NC DEPARTMENT OF  
**HEALTH AND  
HUMAN SERVICES**

October 26, 2023

RE: Popeyes Louisiana Kitchen  
1517 NC 24-97  
Cameron, NC 28326

This letter acknowledges review of the revised plans for the above referenced establishment. The revised plans dated 09/04/23, revised application, email correspondence (responses) are conditionally approved with the following comments:

**1**  
**A2** **EQUIPMENT PLAN**  
SCALE: 1/4"=1'-0"

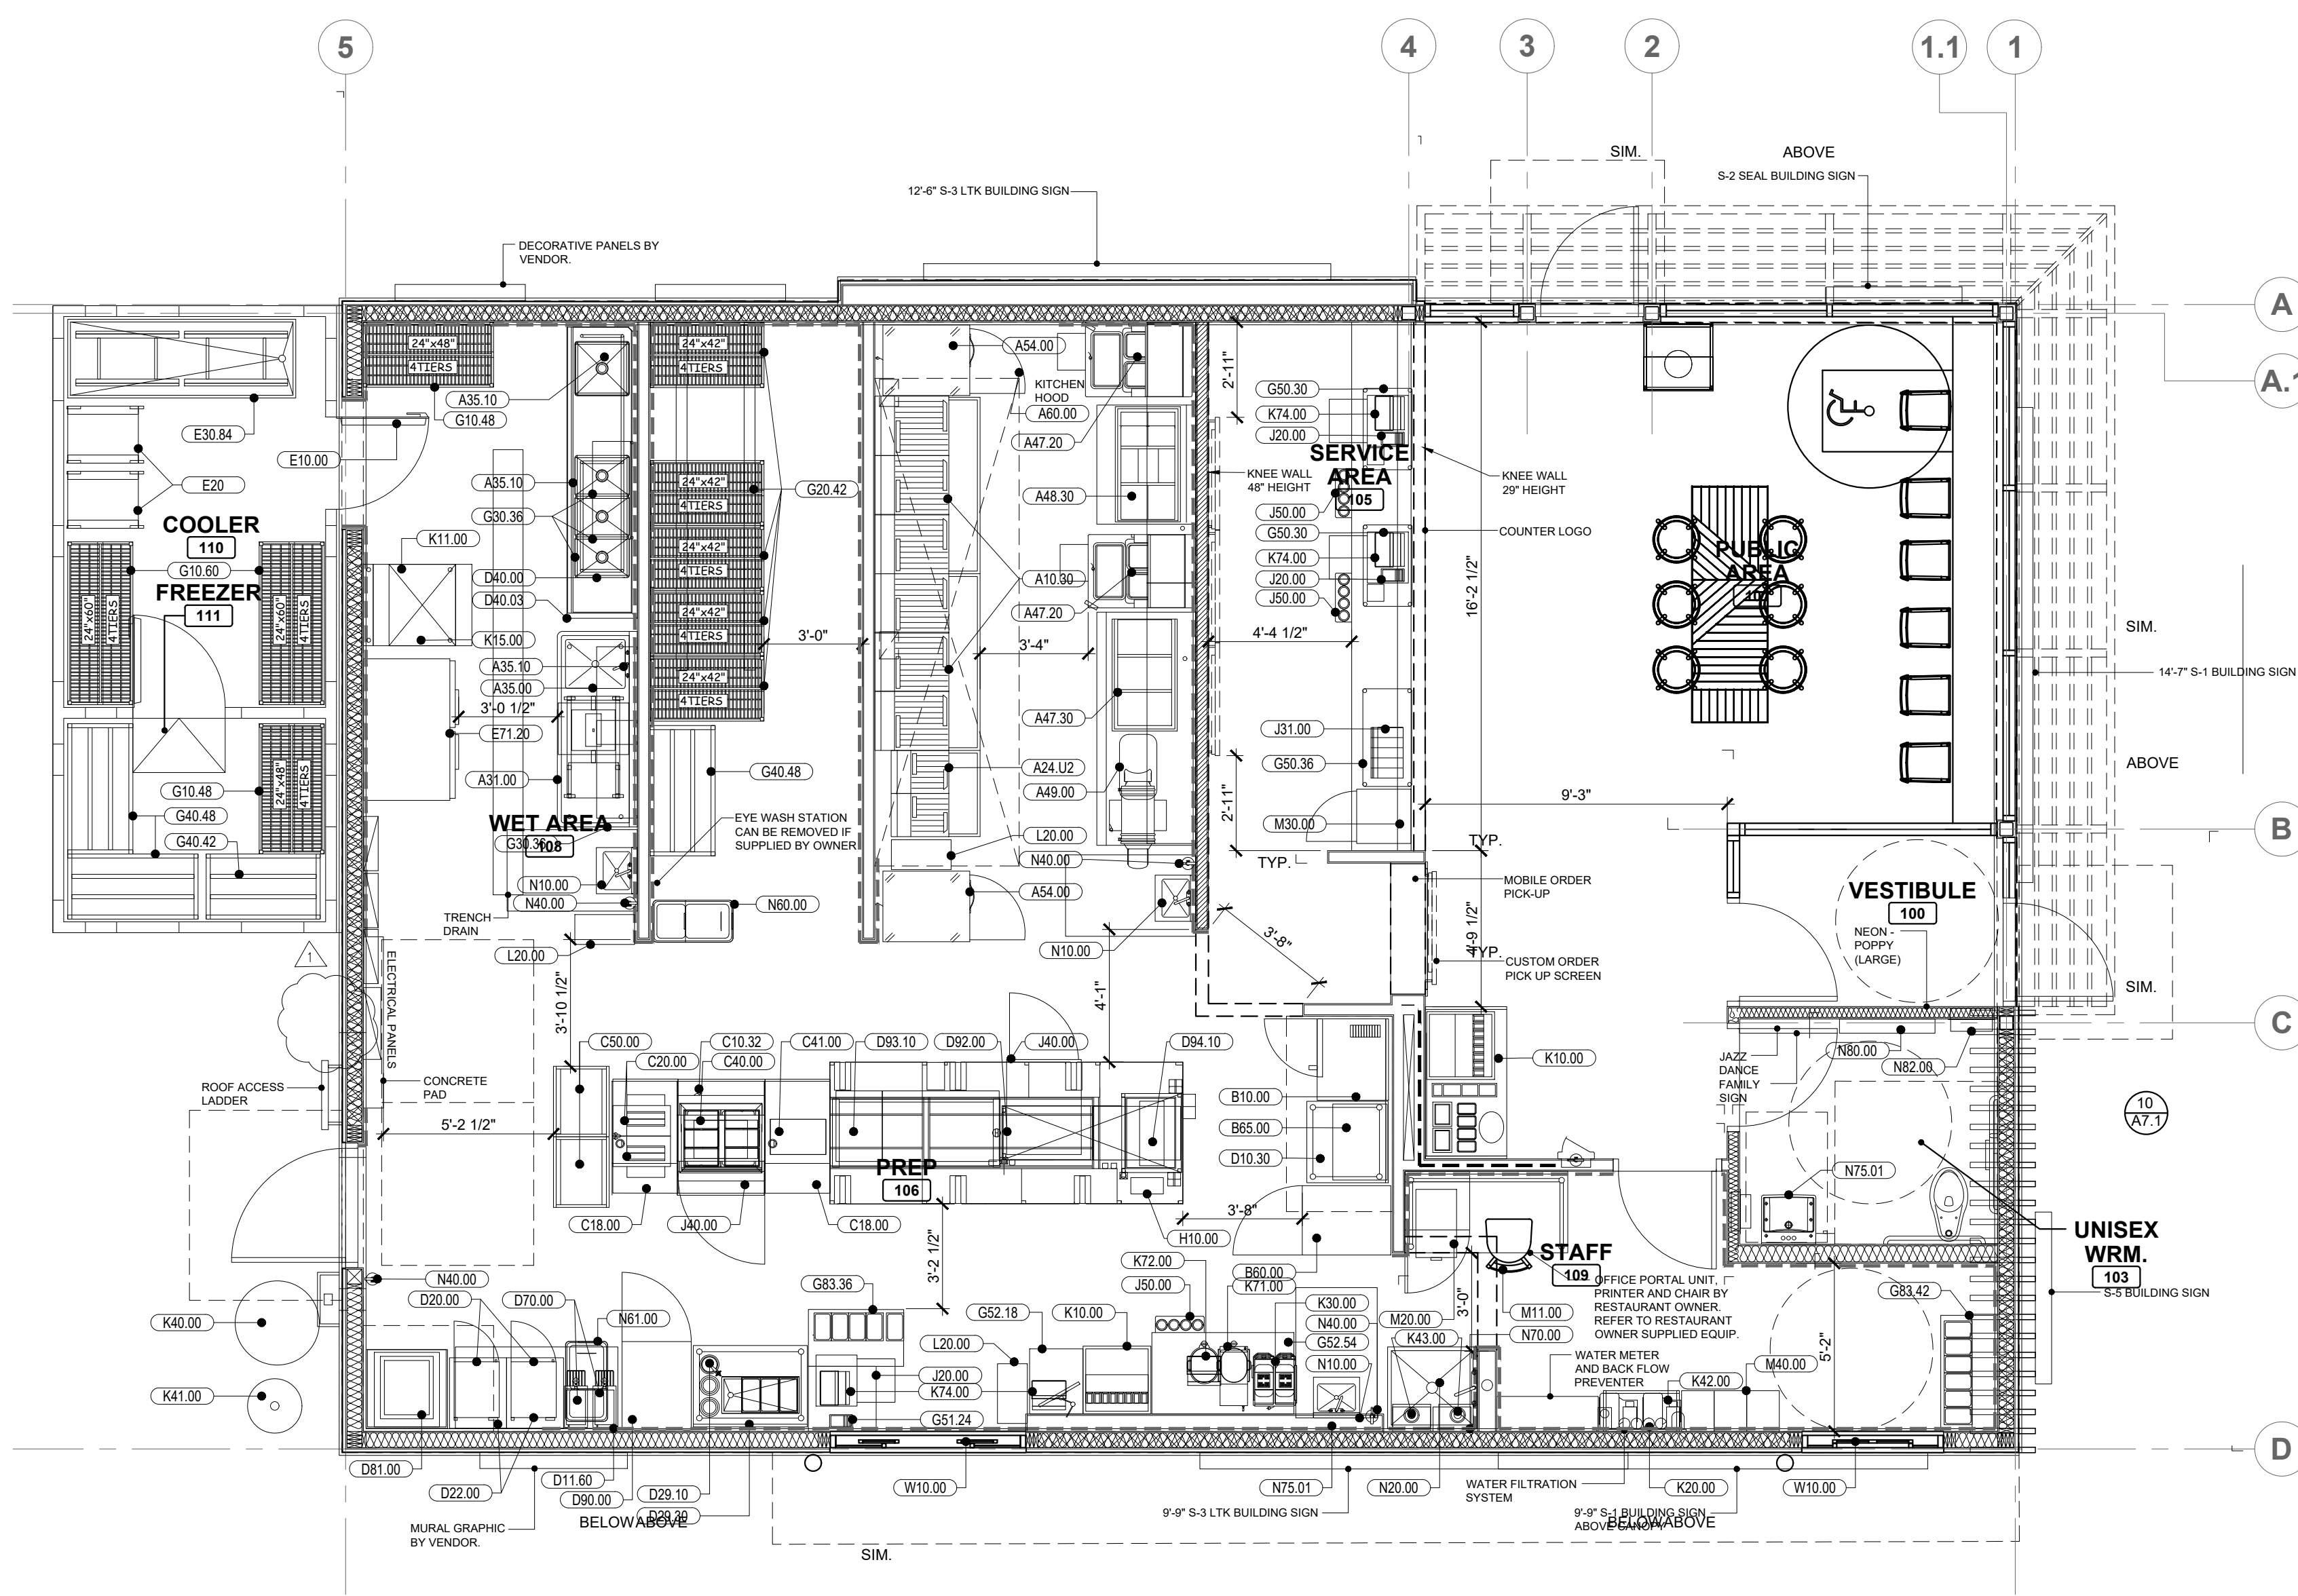
2. The Equipment Plan A2 revised 09/12/23 is approved with the following conditions:
  - a. All food equipment including shelving, custom equipment, counters, and cabinetry must comply with Subpart 4-205 of the North Carolina Food Code and be installed to comply with section 4-402.11 and 4-402.12 of the Code.

- b. As discussed, the 3-compartment sink with pre-rinse shall be self-draining and must be certified or classified for sanitation by an American National Standards Institute (ANSI) accredited certification program, or it must meet Parts 4-1 and 4-2 of the North Carolina Food Code.

- c. As indicated, if handwashing violations are identified in the plan north prep area during inspections related to location and accessibility of hand sinks as specified in paragraphs(A) of Sections 5-204.11 and 5-205.11 of the Food Code additional provisions may be necessary.

- e. No food preparation activities are to occur in the managers/office area.
  - f. Hands-free faucets must comply with NC Food Code 5-202.12 which requires a temperature of 100 degrees F. flow of water for at least 15 seconds without the need to reactivate the faucet.

- h. As indicated in email correspondence a mechanical dishwasher is not to be installed.

Drawn	Checked
Scale	Date JUNE 2023
Project No. C22-129	Drawing No. A9.1

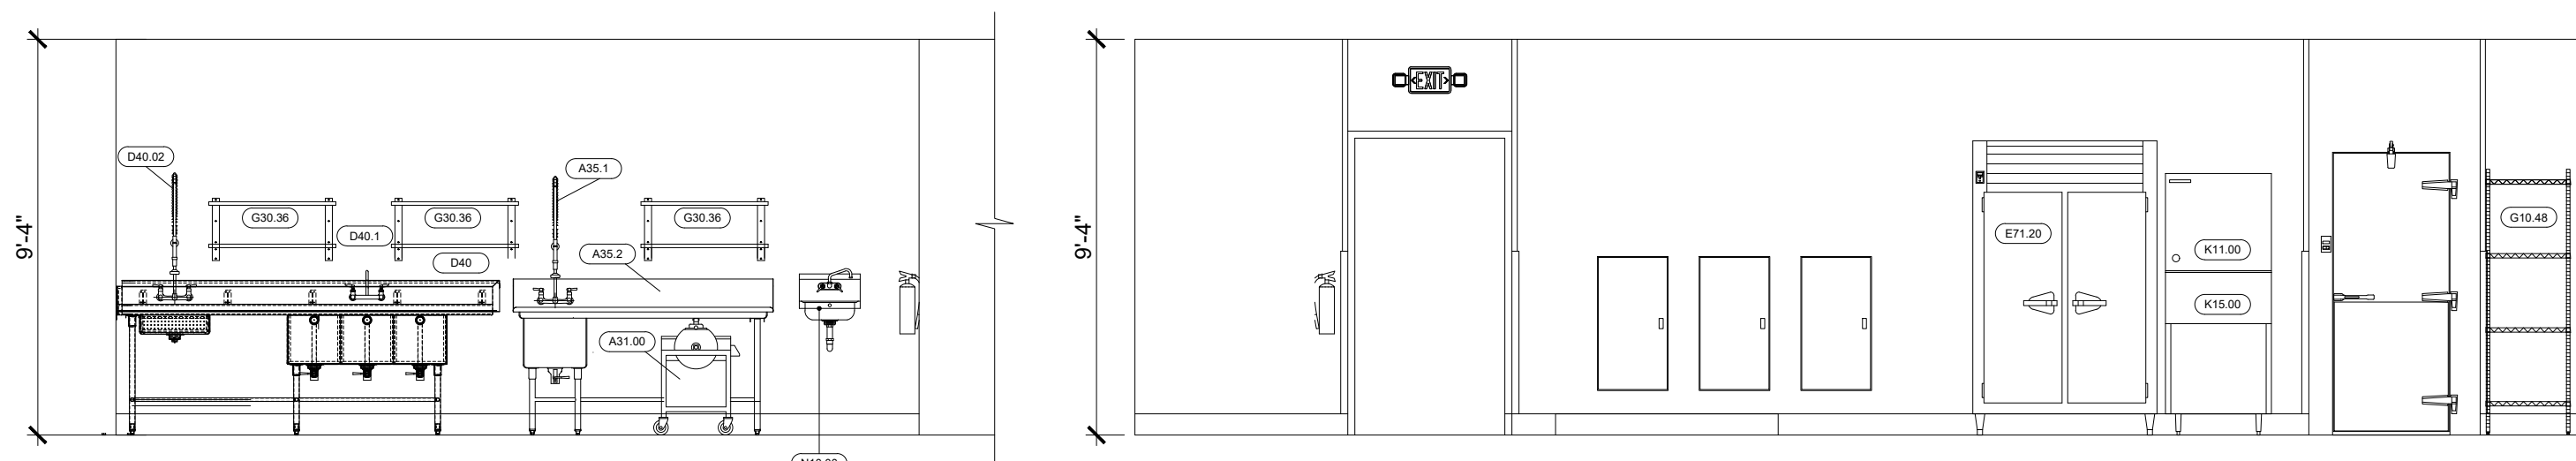
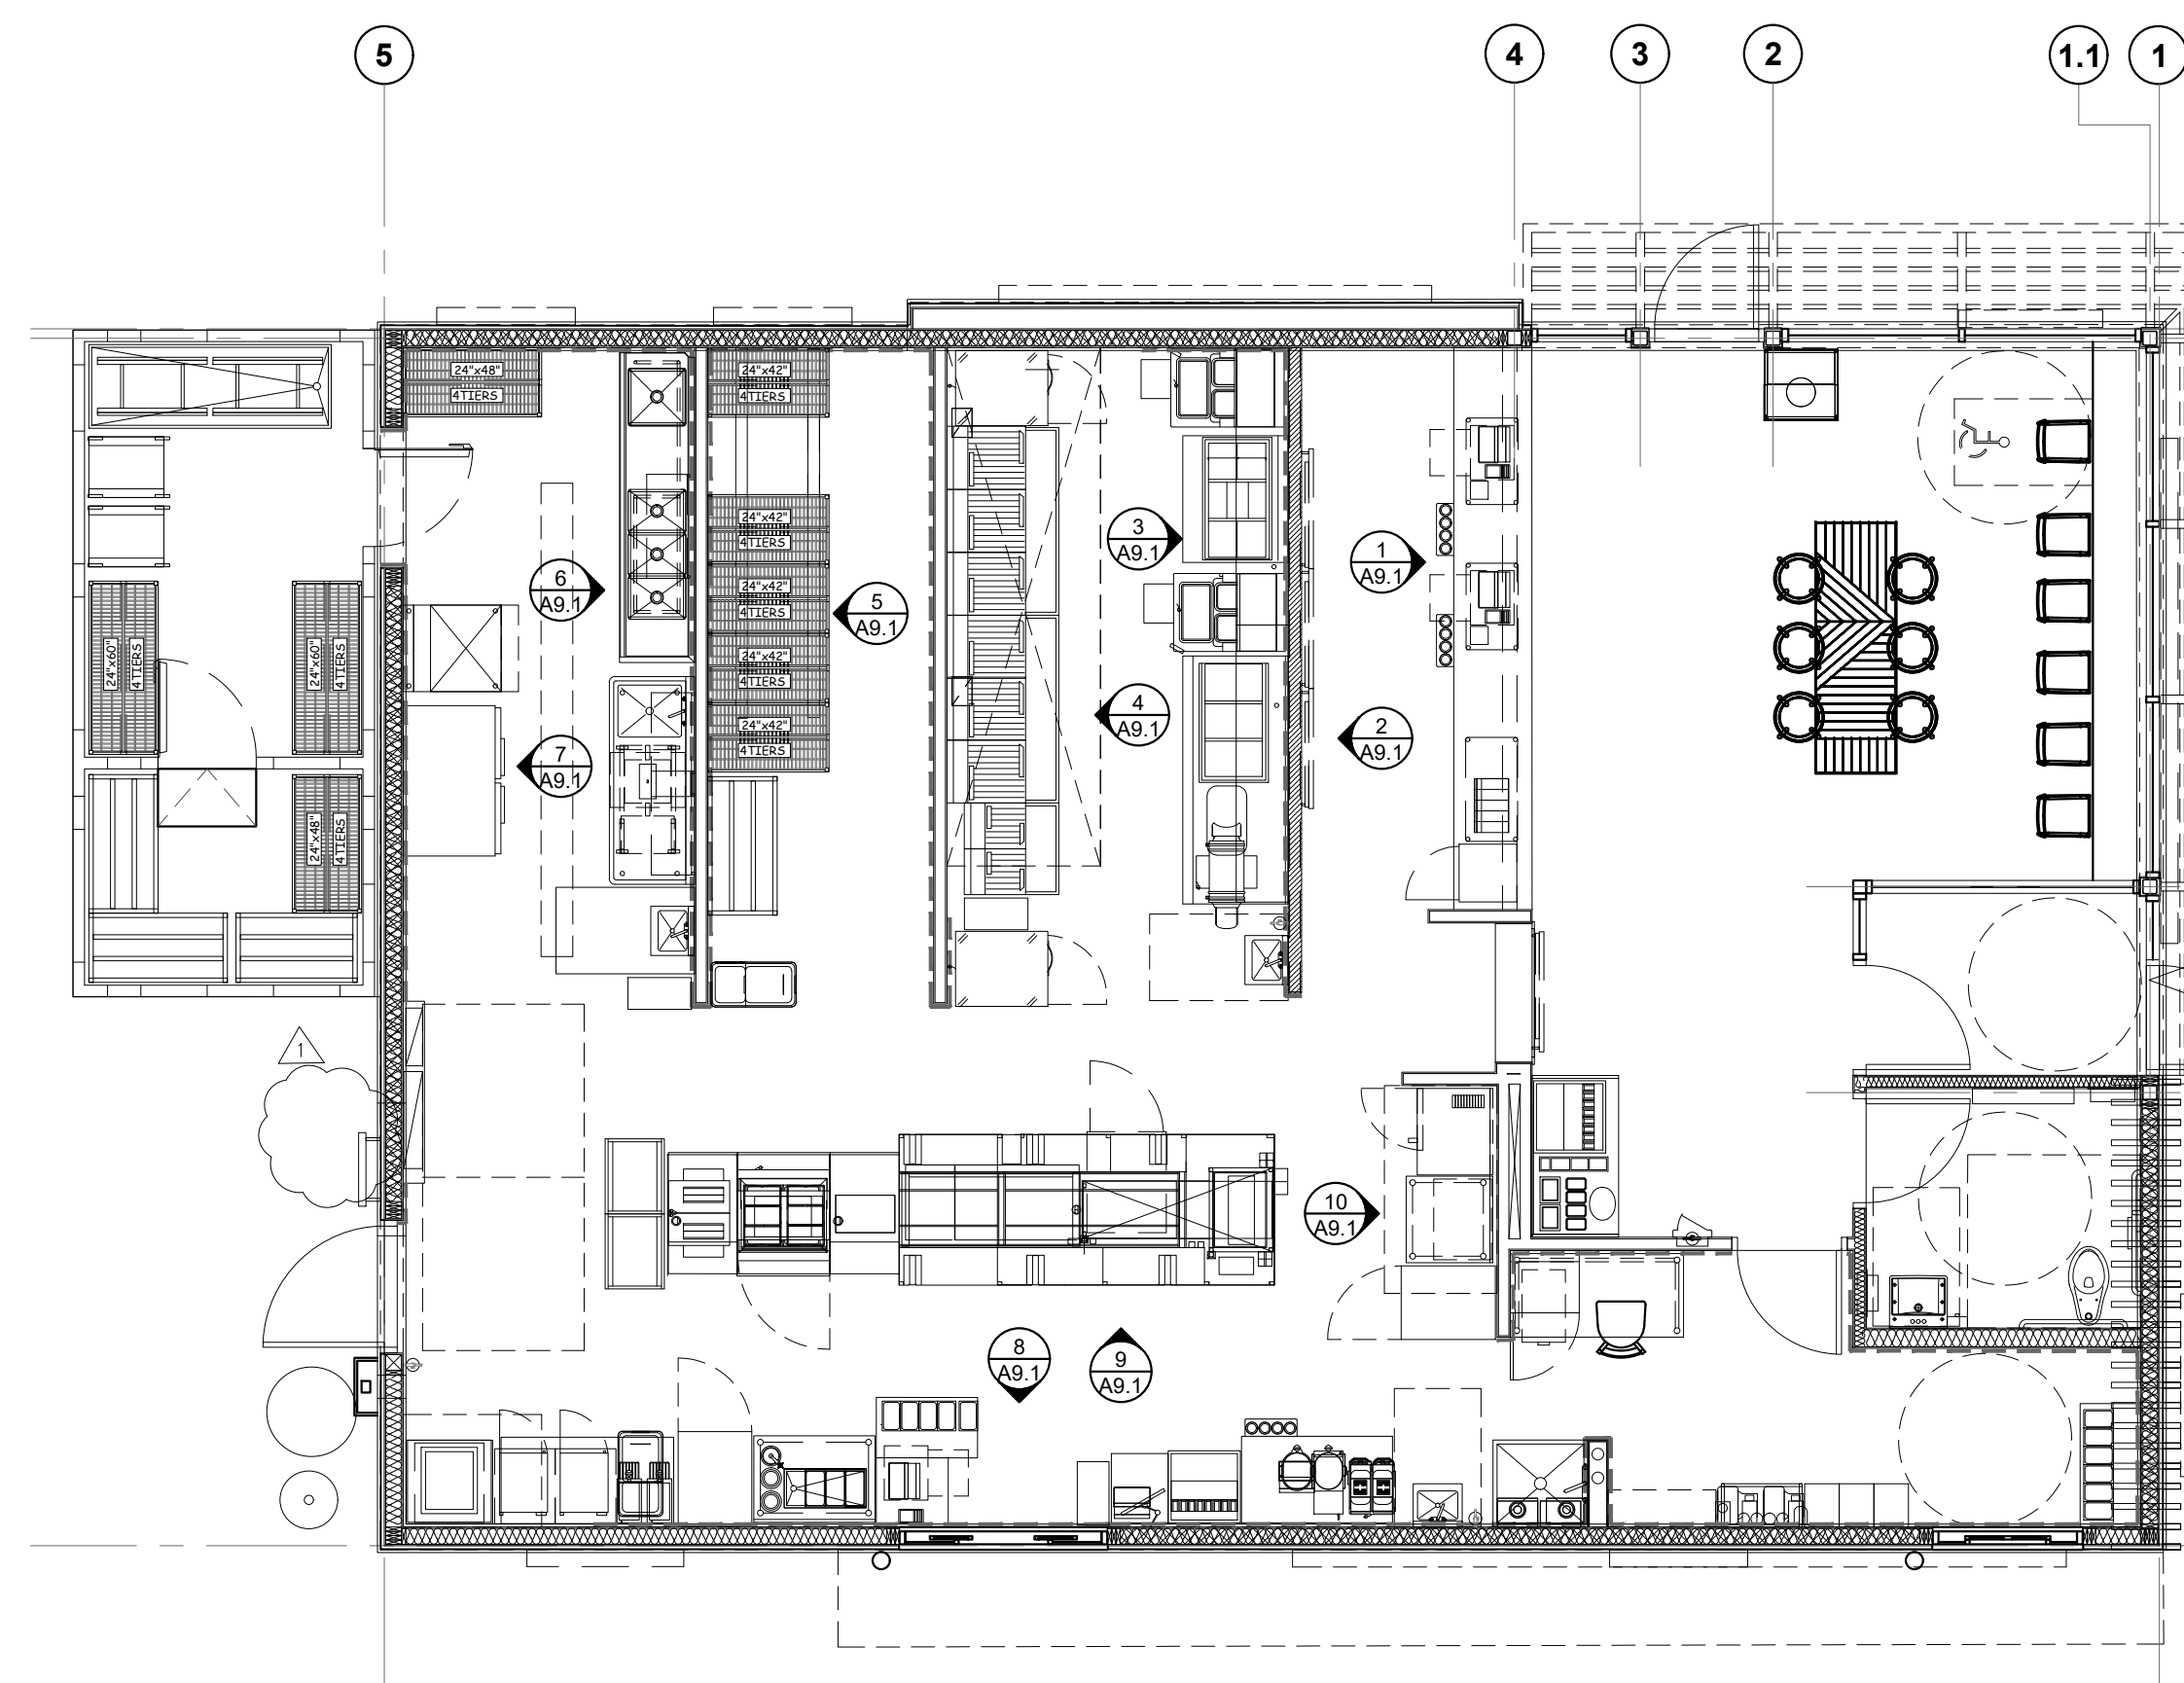
- d. Splash guards will be installed between handwashing sinks and adjacent equipment where splash contamination from hand washing is a concern as noted on plan sheet A9.1.
